From: Michael Eastham
Sent: 14 March 2022 13:54
To: Planning.Responses
Subject: FW: Phase 5 (LU/206/21/RES) - LEAP design
Attachments: LA.PH5_8.1[E]_LEAP.pdf; LA.PH5_109[E]_Plant schedules.pdf; 546 - PHASE 5 - DRAWING REGISTER P4 - 14.03.2022.pdf; LA.PH5_1[E]_Landscape Strategy.pdf

Please upload onto Ocella the **SUBSTITUTE plans (attached)** for **LU/206/21/RES**.

- Drawing No. LA.PH5.1 **Rev. E** - Landscape Strategy - Overall Development
- Drawing No. LA.PH5.8.1 **Rev. E** - Landscape Strategy - Play Areas - LEAP
- Drawing No. LA.PH5 109 **Rev. E** - Materials and Plant Schedule

Further to my recent telephone conversation with Sue Howell – please find attached the revised LEAP / Landscaping plans for Phase 5.

LA.PH5.109

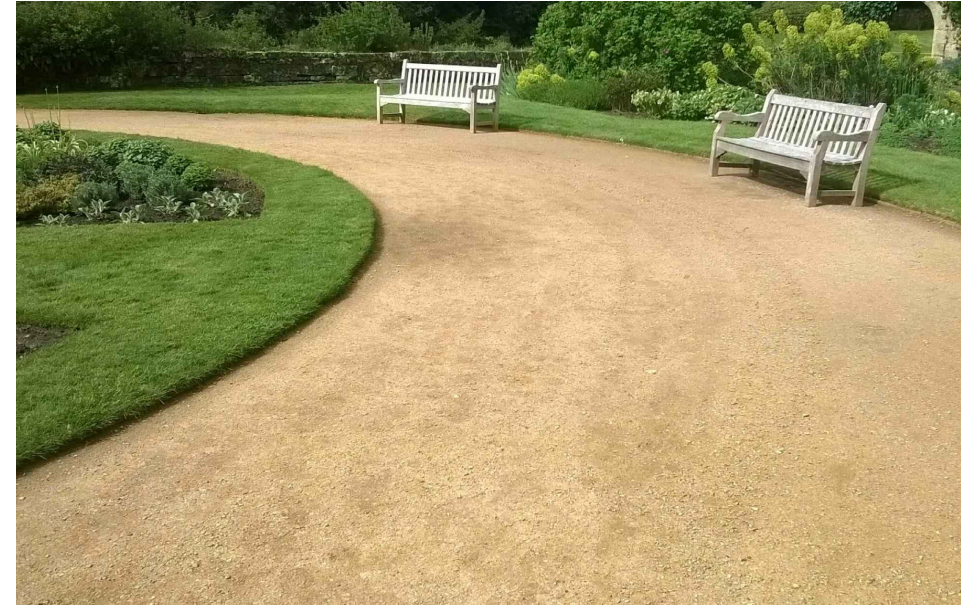
The changes were to change the type of surface treatment of the LEAP to being '**Bonded Rubber Mulch**' throughout and to remove the use of bark mulch and self-binding gravel altogether.
